Subject: Retreat at TimberRidge Filing No. 3 Final Plat (SF-22-041)

The Park Operations Division of the Community Services Department has reviewed the Retreat at TimberRidge Filing No. 3 Final Plat development application and has the following preliminary comments of behalf of El Paso County Parks. This application and its recommendations will be presented to the Park Advisory Board for endorsement on February 8, 2023:

The Retreat at Timber Ridge Filing No. 3 Final Plat Review

**ARROYA LANE EXISTING 24" DIP PUBLIC WATER MAIN RELOCATION PLAN**

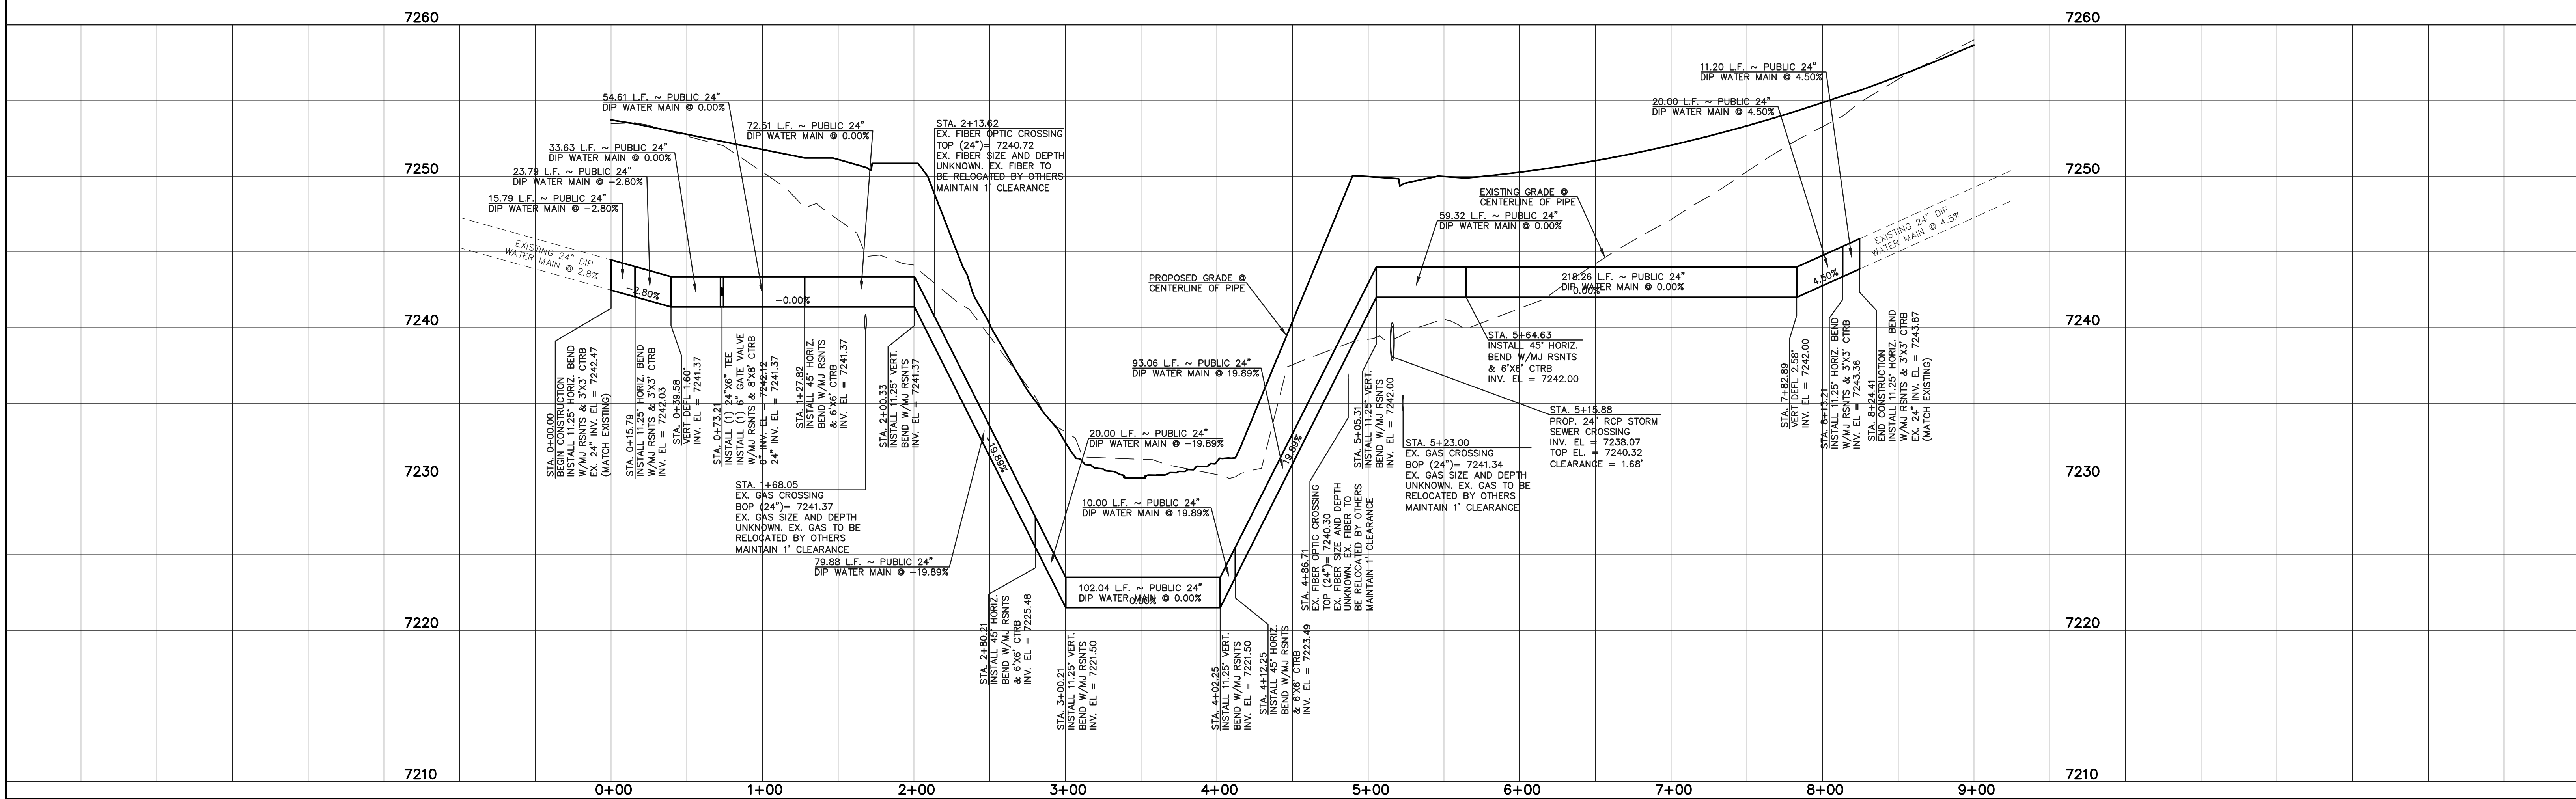
west of Sand Creek. While the 2018 Retreat at TimberRidge Preliminary Plan did highlight the trail corridor along Arroyo Lane, only the Filing No. 3 Construction Drawings show what appears to be a trail along the south side Arroyo Lane. If the Arroyo Lane Regional Trail easement is indeed located within Tracts A-D and outside of the designated Arroyo Lane right-of-way, the plan must be symbolized and annotated to show them in a clear and discernable manner.

RETREAT AT TIMBERRIDGE
FLING NO. 3
JOB NO. 1185.30
DECEMBER 8, 2022
SHEET 2 OF 5

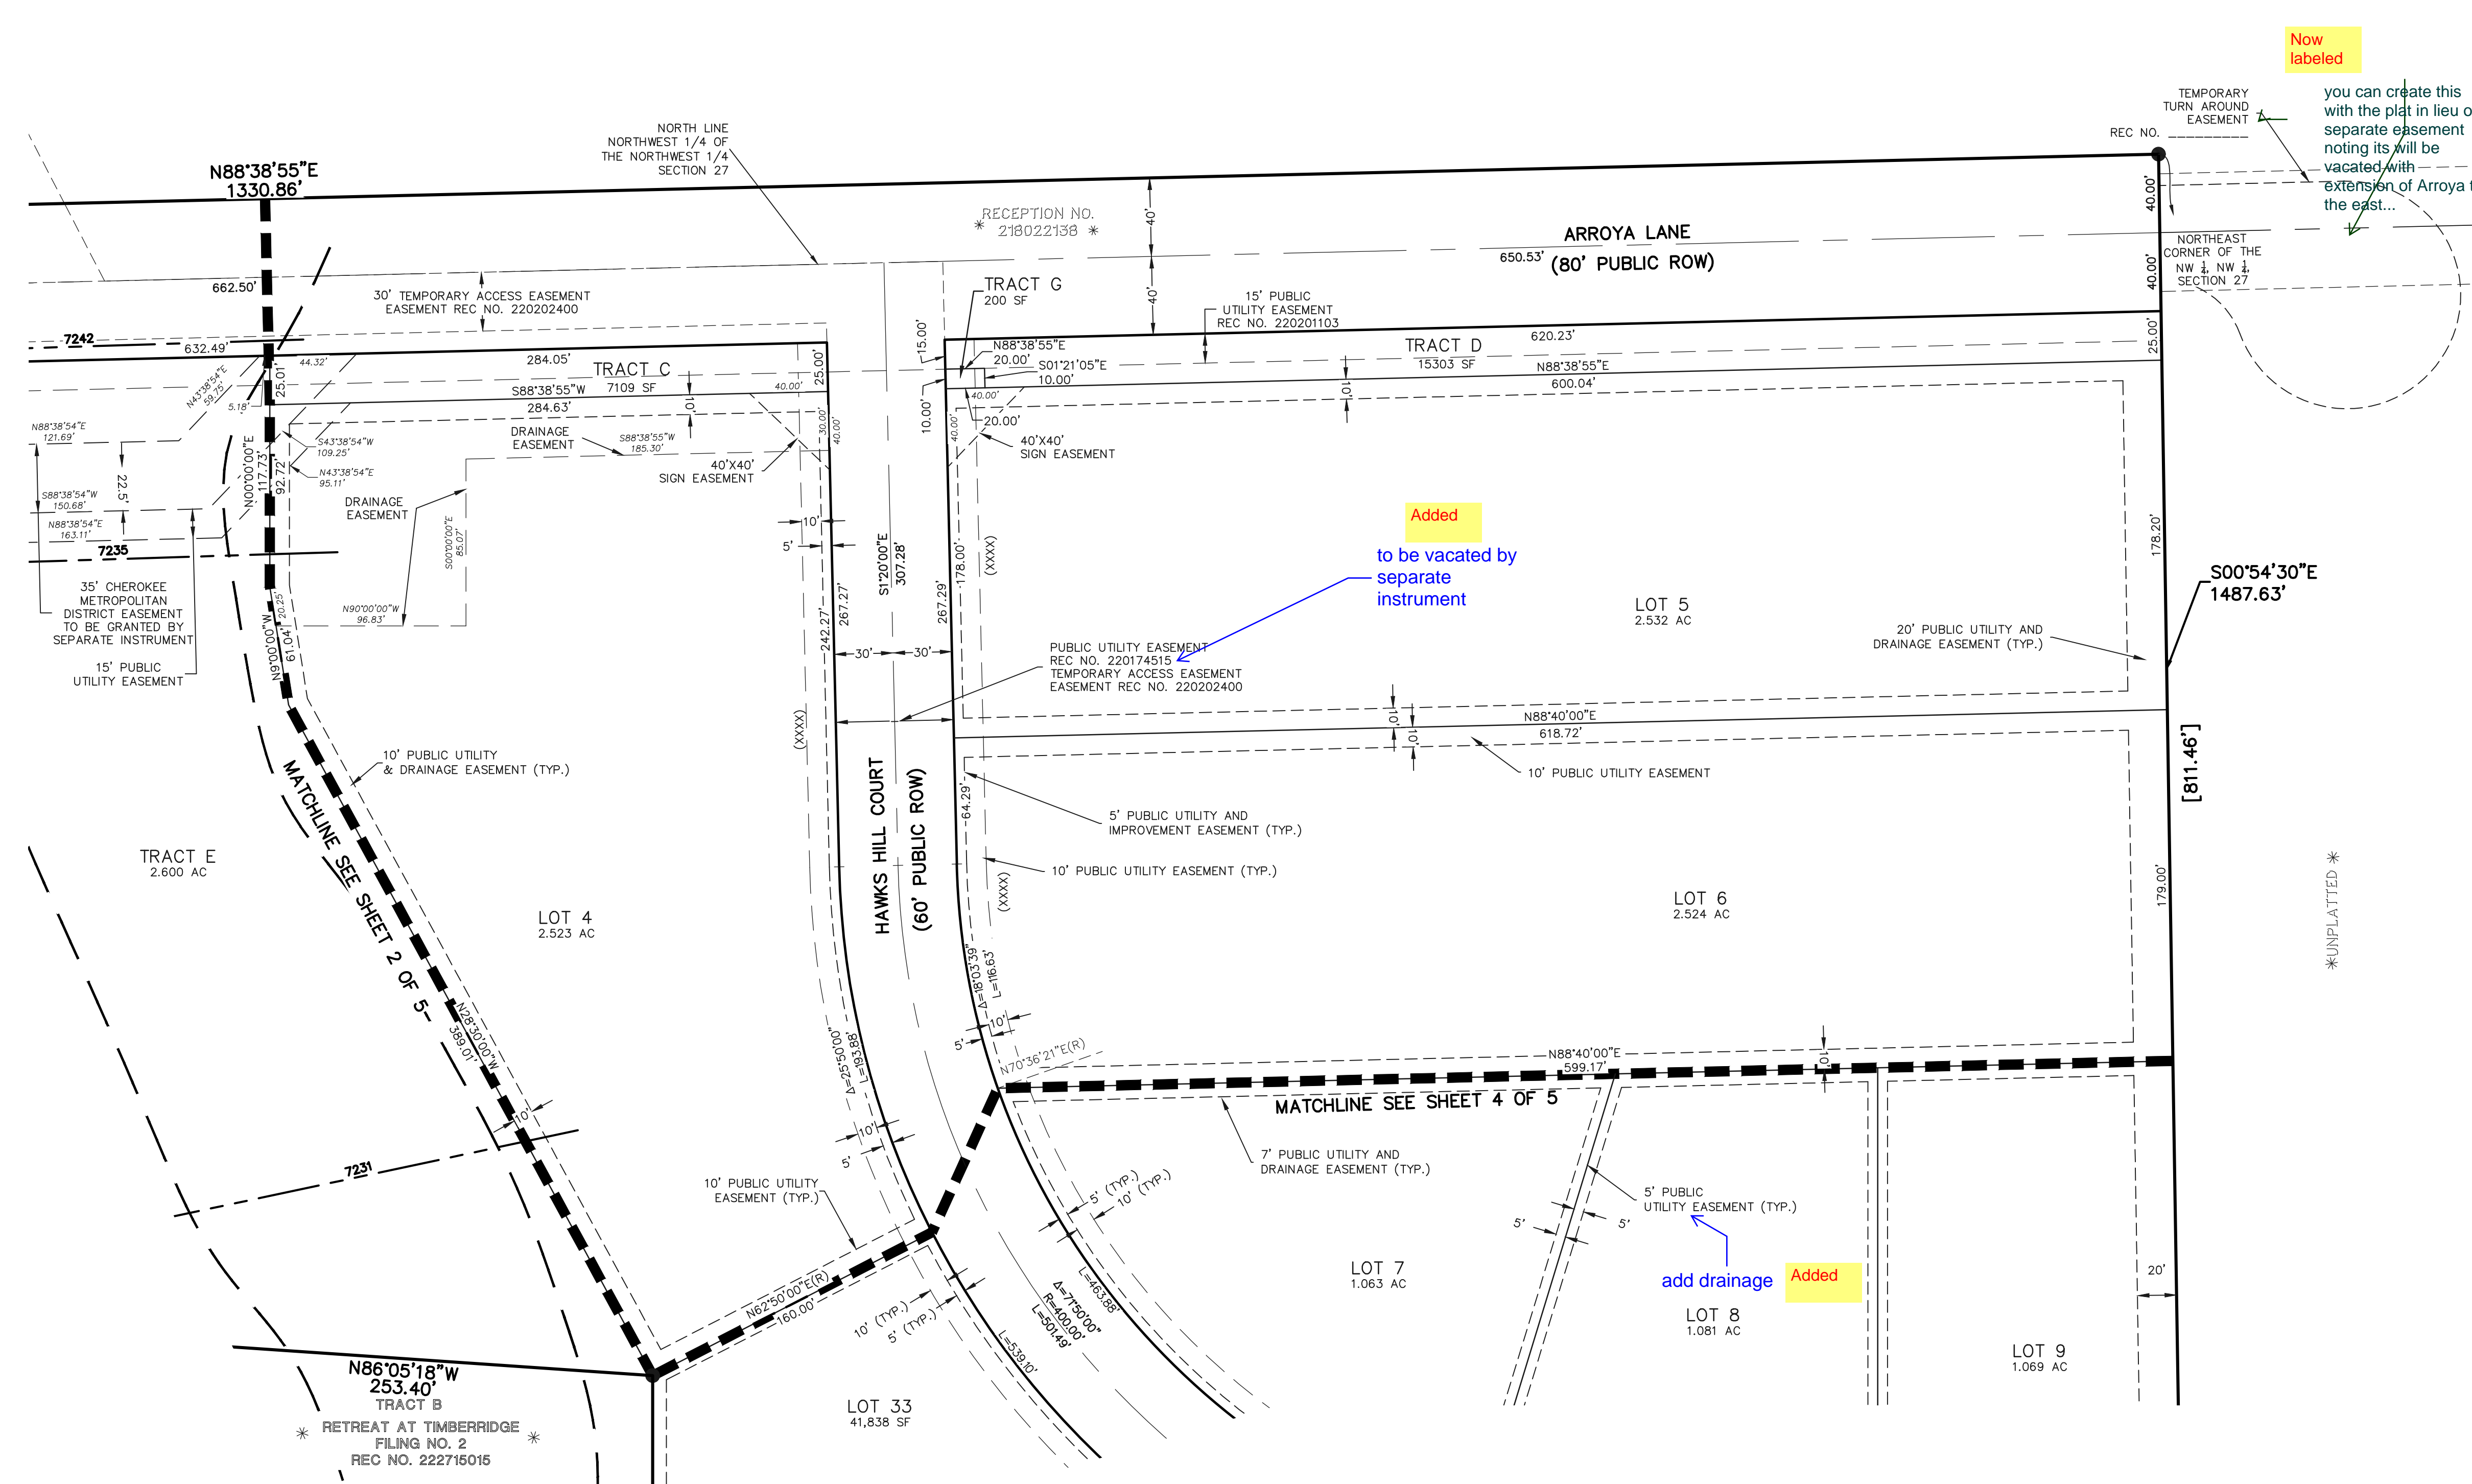
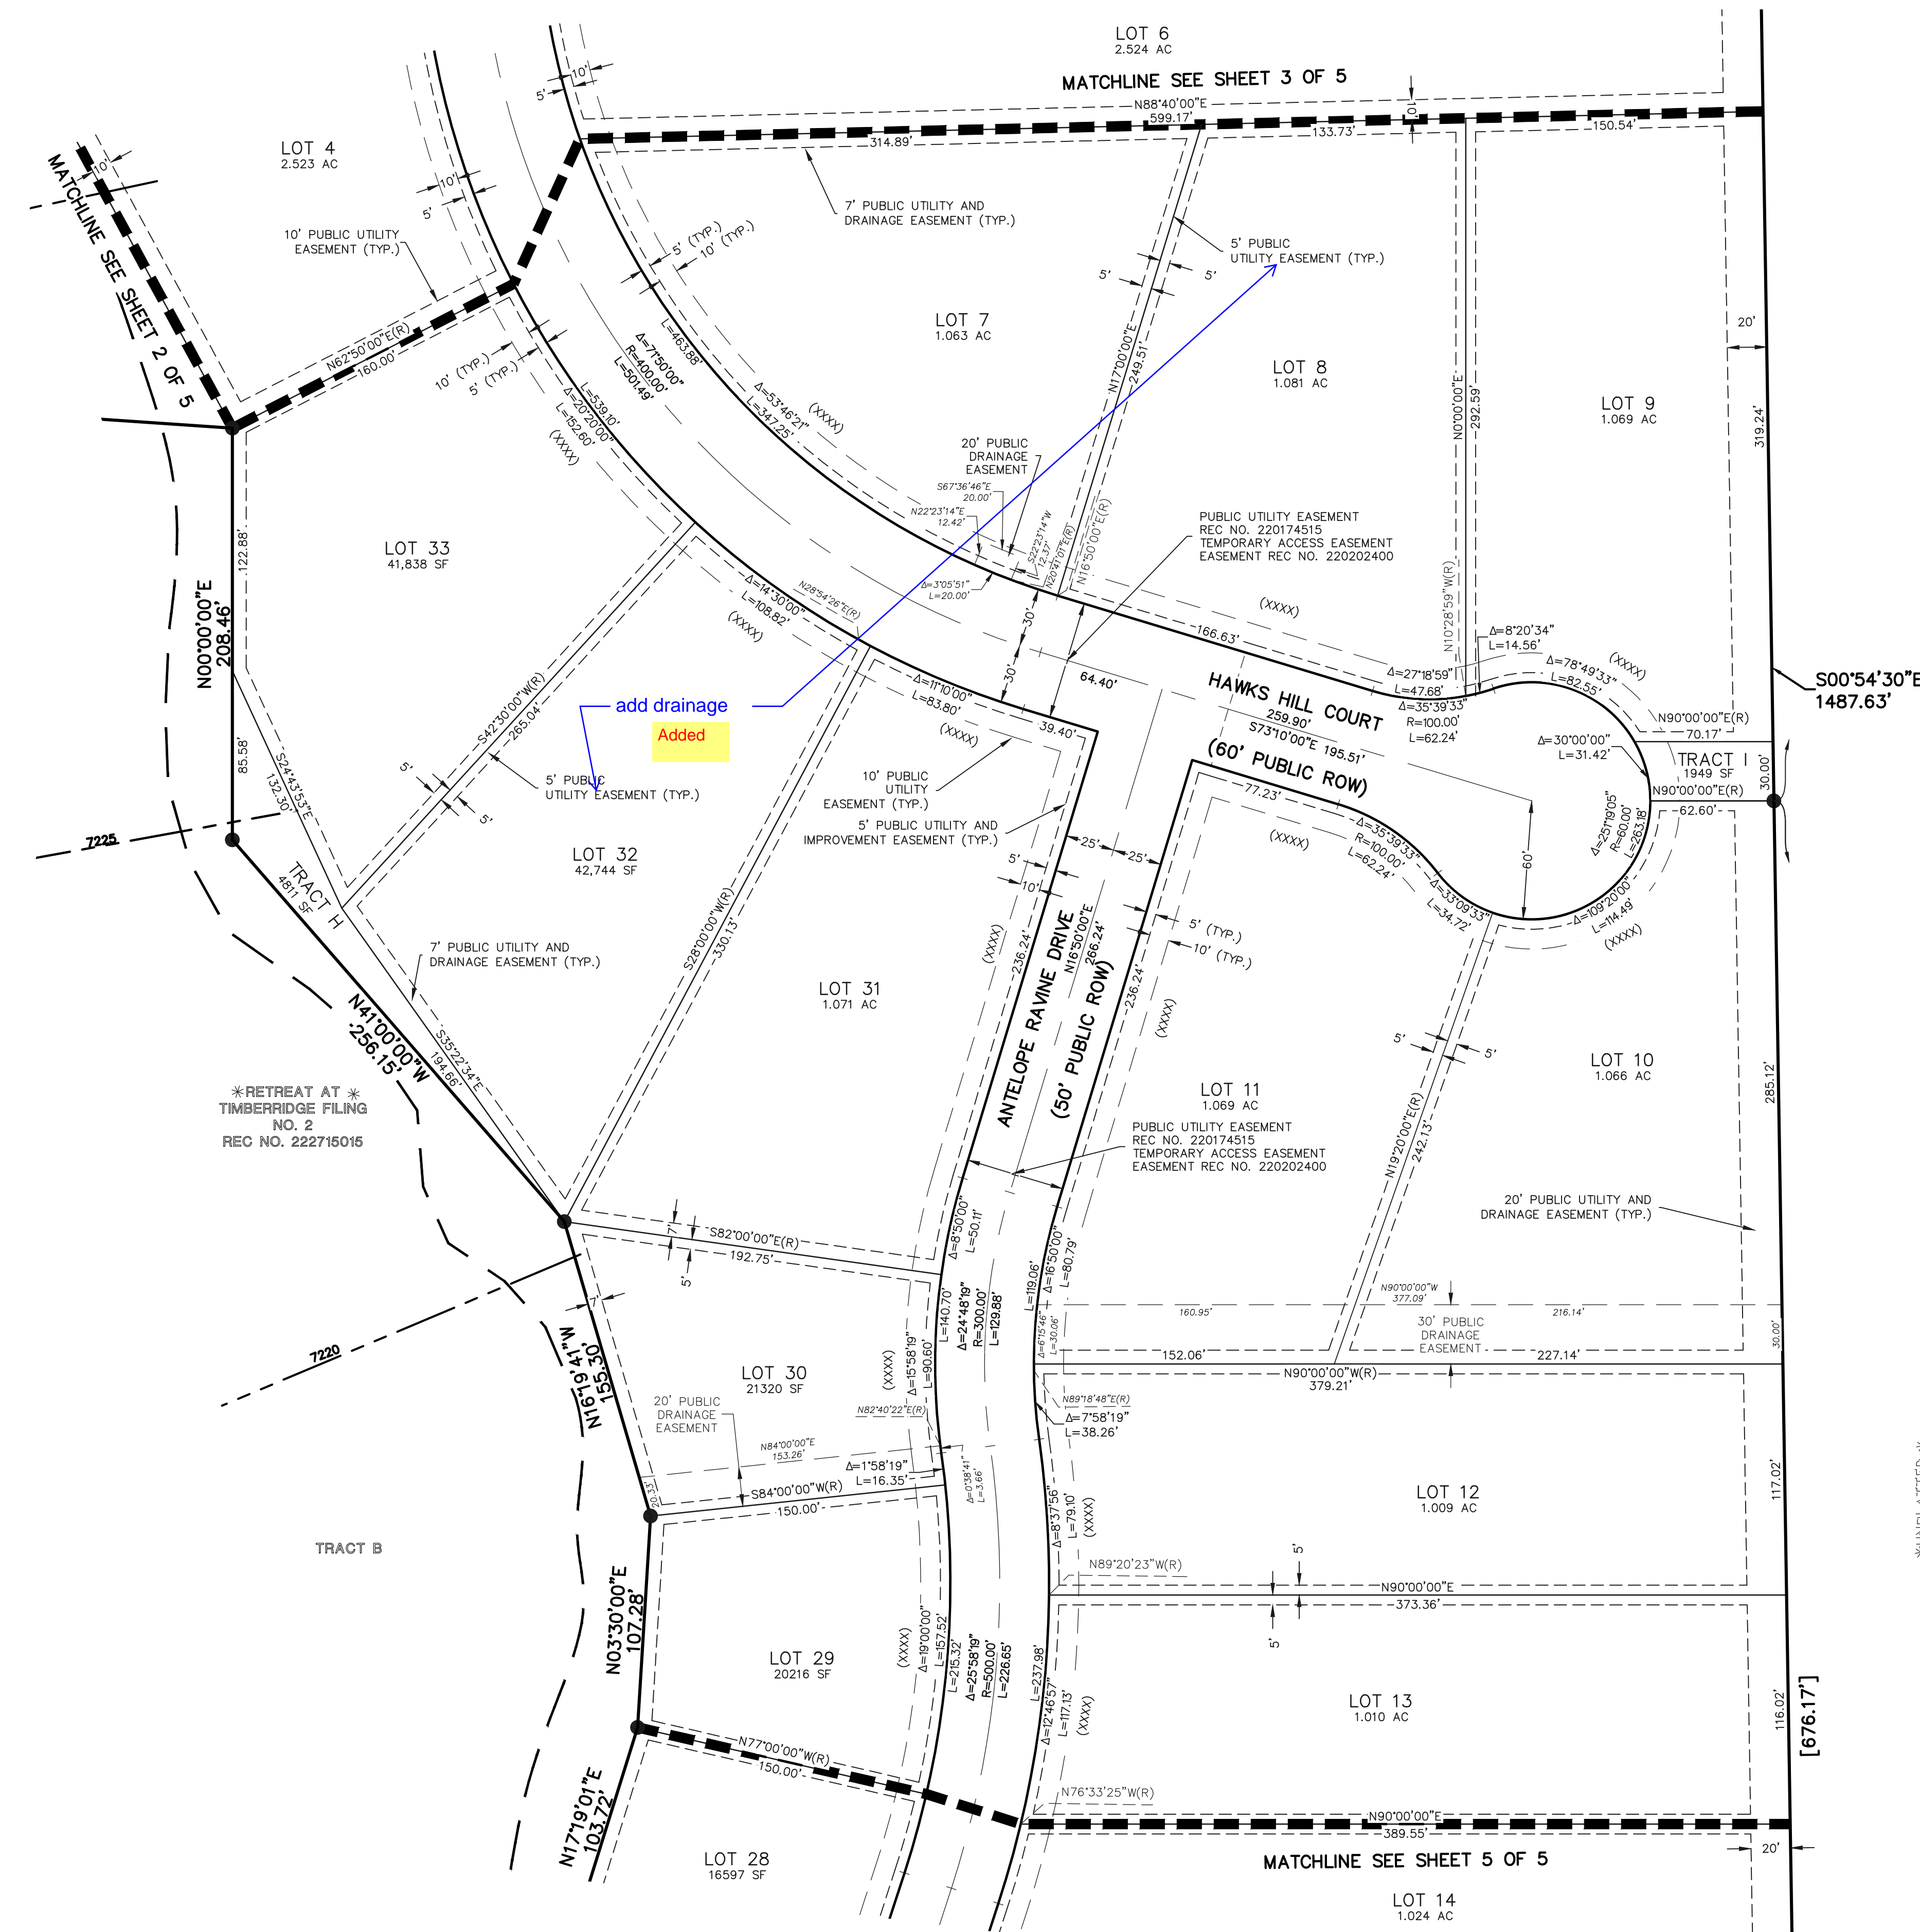
The Retreat at TimberRidge Filing No. 3 Final Plat shows a 30' trail easement dedicated to the Sand Creek Regional Trail, running north-south on the west side of Sand Creek. According to the plat, this trail easement terminates at Arroyo Lane, and no additional trail easements are designated along Arroyo Lane, either east or

"The Park Advisory Board recommends that the Planning Commission and the Board of County Commissioners include the following conditions when considering and/or approving the Retreat at TimberRidge Filing No. 3 Final Plat: (1) provide to El Paso County a 25-foot public trail easement along the west side of the Sand Creek Drainage from the southern plat boundary to Arroyo Lane that allows for public access, as well as construction and maintenance by El Paso County of the Sand Creek Primary Regional Trail, and this easement shall be shown on and dedicated to El Paso County prior to the recording of this Final Plat; (2) provide to El Paso County a 25-foot public trail easement along the south side of Arroyo Lane outside of the public Right-of-Way, from the eastern plat boundary to Vollmer Road that allows for public access, as well as construction and maintenance by El Paso County of the Arroyo Lane Primary Regional Trail, and this easement shall be shown on and dedicated to El Paso County prior to the recording of this Final Plat; (3) require fees in lieu of land dedication for regional park purposes in the amount of \$15,180 and urban park purposes in the amount of \$9,570 to be paid upon recording of this Final Plat."
